ABP Reference: ABP-317810-23

RE: Open cycle gas turbine power plant and associated infrastructure Land to the north of Tynagh Power Station, Derryfrench, Tynagh, Loughrea, Co. Galway Response to Submissions

The submission by the Health and Safety Authority (HSA) has raised a number of points relating to the COMAH Land Use Planning Assessment. An updated COMAH Land Use Planning Report has been prepared by Byrne O'Cleirigh, with individual responses to each point set out below.

Figure 2: Wind Rose for Athenry meteorological station (2018 – 2022)

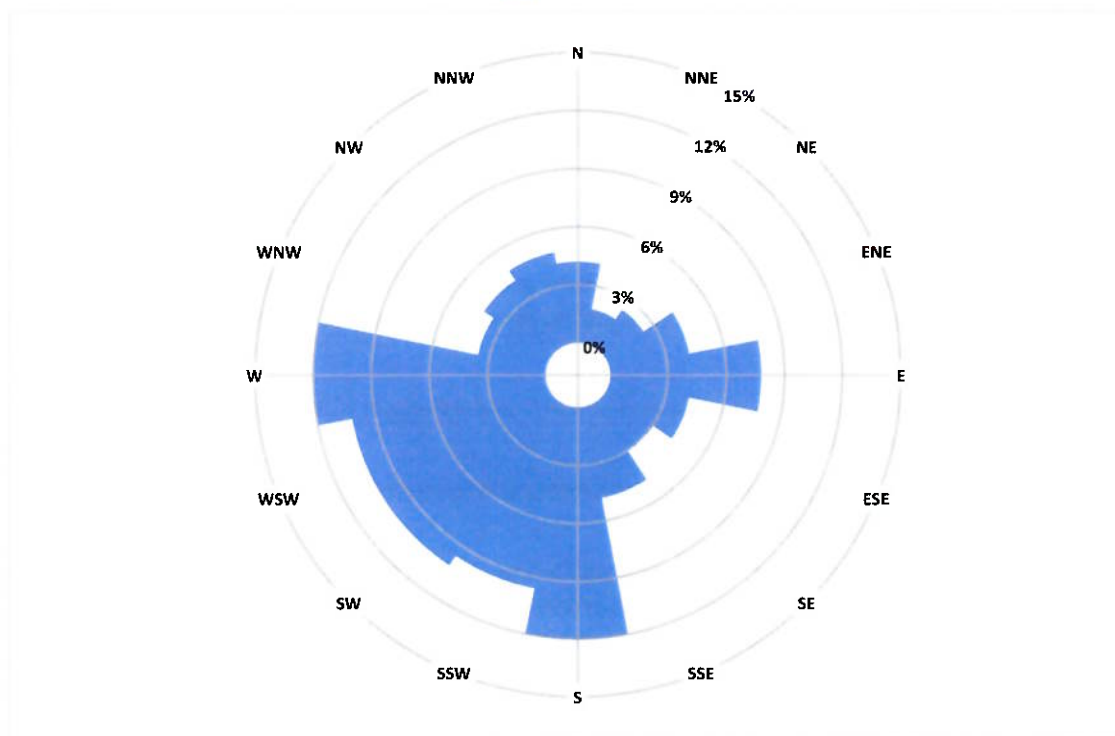
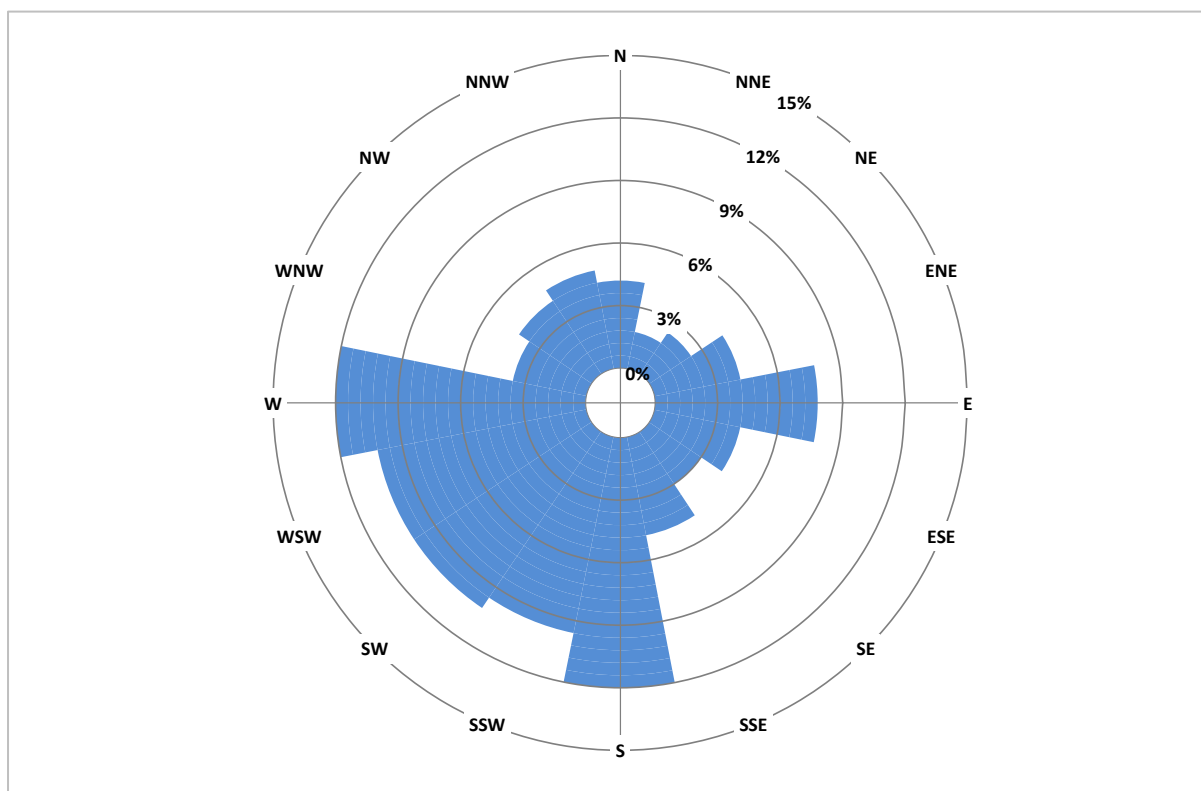
4.12	Data on flash fires for gas releases	Section 5.2.2.2 — provide detail on meteorological data probabilities (i.e. 80/20 for D5/F2) or wind rose, which are relevant for flash fires for gas releases.	Flash fires and vapour cloud explosions, depend on both wind speed and atmospheric stability. These events have been assessed under two meteorological conditions: (i) Typical conditions (D5): a wind speed of 5 m/s and a Pasquill stability class of D, assumed to occur 80% of the time

(ii) Calm conditions (F2): a wind speed of 2 m/s and a Pasquill stability class of F, assumed to occur 20% of the time. The data in Table 5 of the updated report shows that the wind speed is less than 5 m/s approximately 75.2% of the time, and is greater than 5 m/s approximately 24.8% of the time; these frequencies have been applied to the 'low' and 'high' wind speeds for assessing the impacts from fire eventsRefer to Section 5.1 of updated report.

Figure 3: Key Tank and Bund dimensions for calculation of bund overtopping

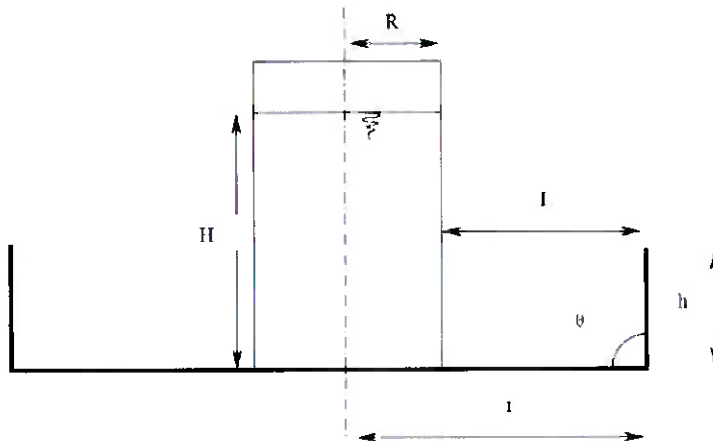
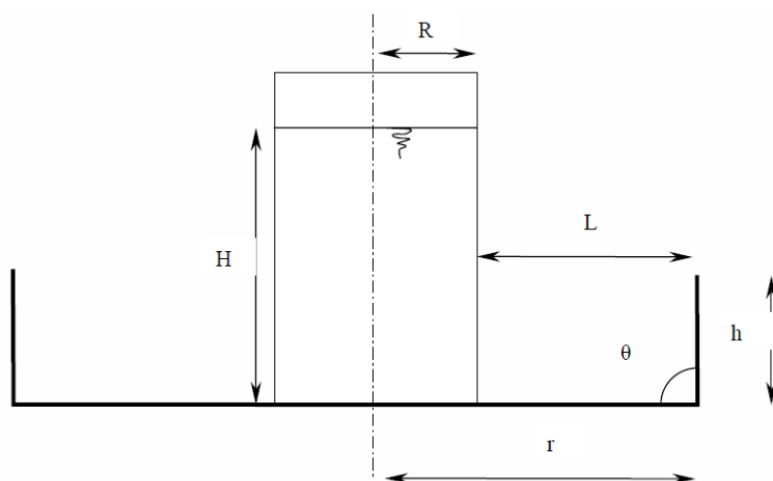
4.17	Frequency of overtop pool fire	Section 5.3.2 — what frequency has been used for an overtop pool fire? TLUP Section 3.6.3 indicates 5 x 10-8/yr per tank, provide further detail.	A probability of 5 x 10 ⁻⁸ per year was applied for the unbunded pool fire scenario. A statement to this effect has been added to Section 6.4.1.

APPENDIX 2: INDIVIDUAL RISK CONTOURS

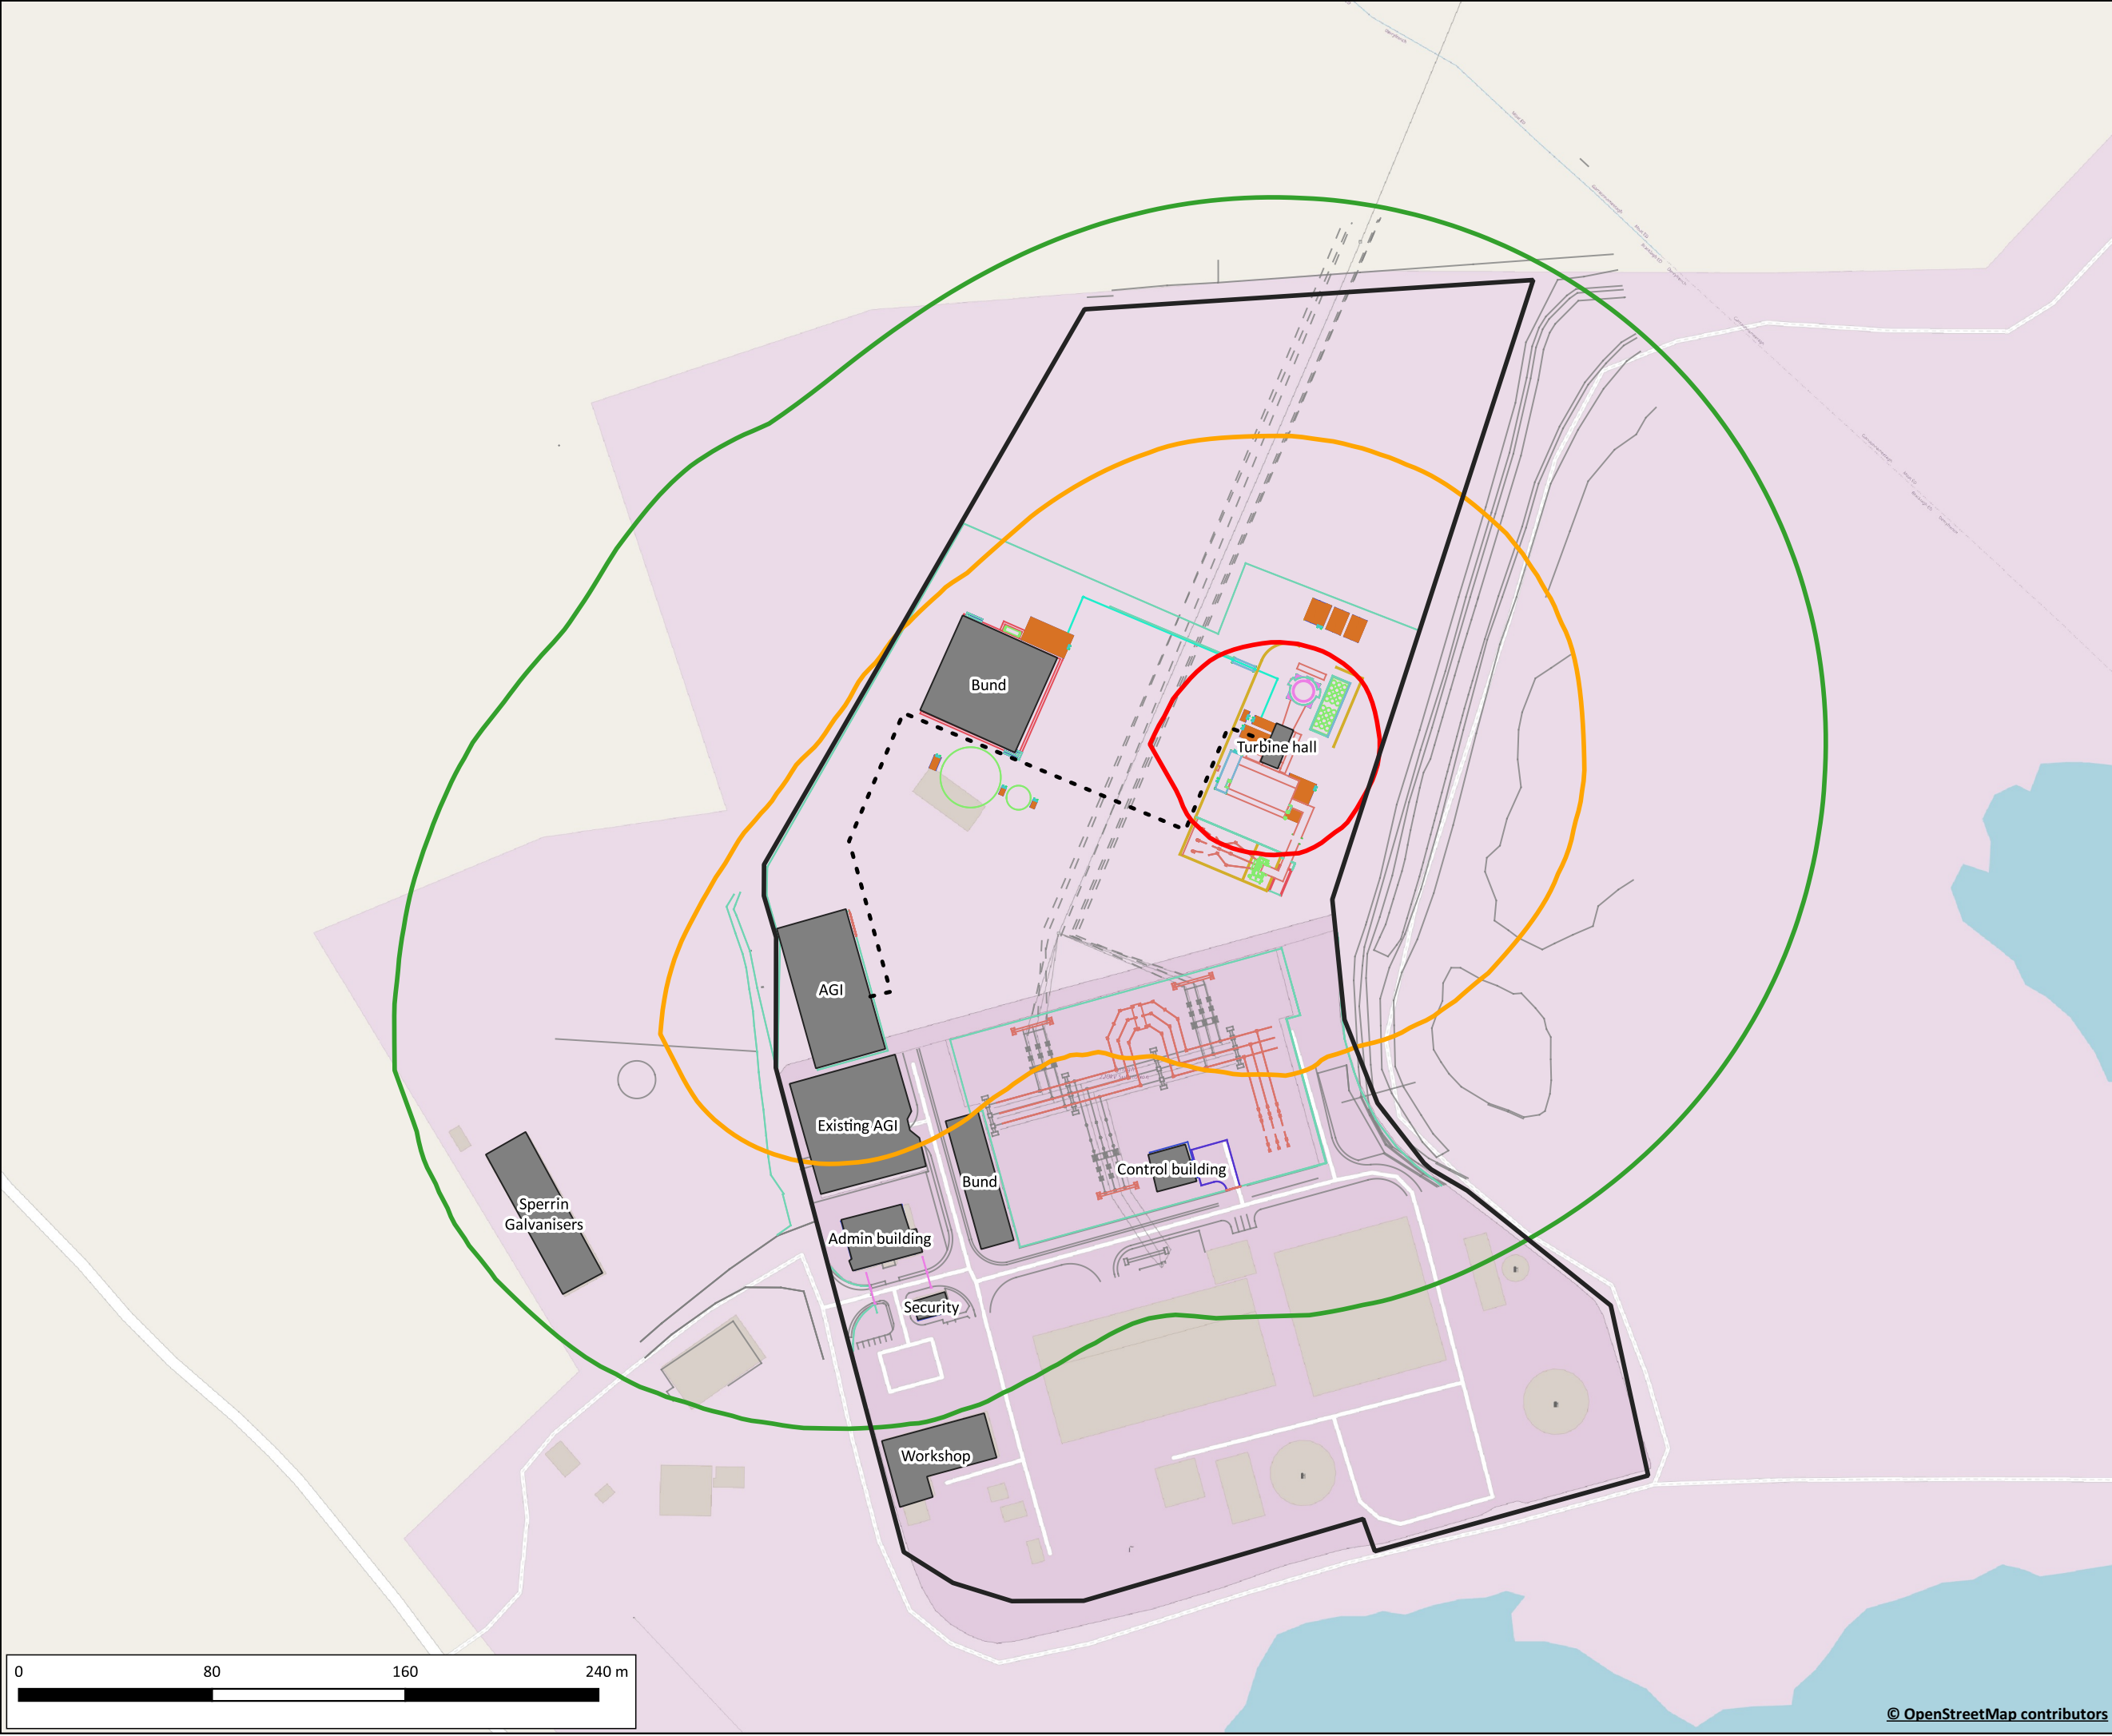
4.8	Gas pipeline	Section 5.2.1 - actual diameter and routes of the 75 bar and 30 bar gas pipelines to be set out. (250mm seems to be an 'example').	The diameter of the proposed natural gas pipelines is 250 mm. The routes of the above- and below- ground sections of natural gas pipeline are shown in the map in Appendix 2 of the report.

4.22	Location of areas	Section 7.3 Table 13 — the location of all these areas should be shown on a site drawing.	For clarity, the security building, control room and workshop have been added to the drawing in Appendix 2.
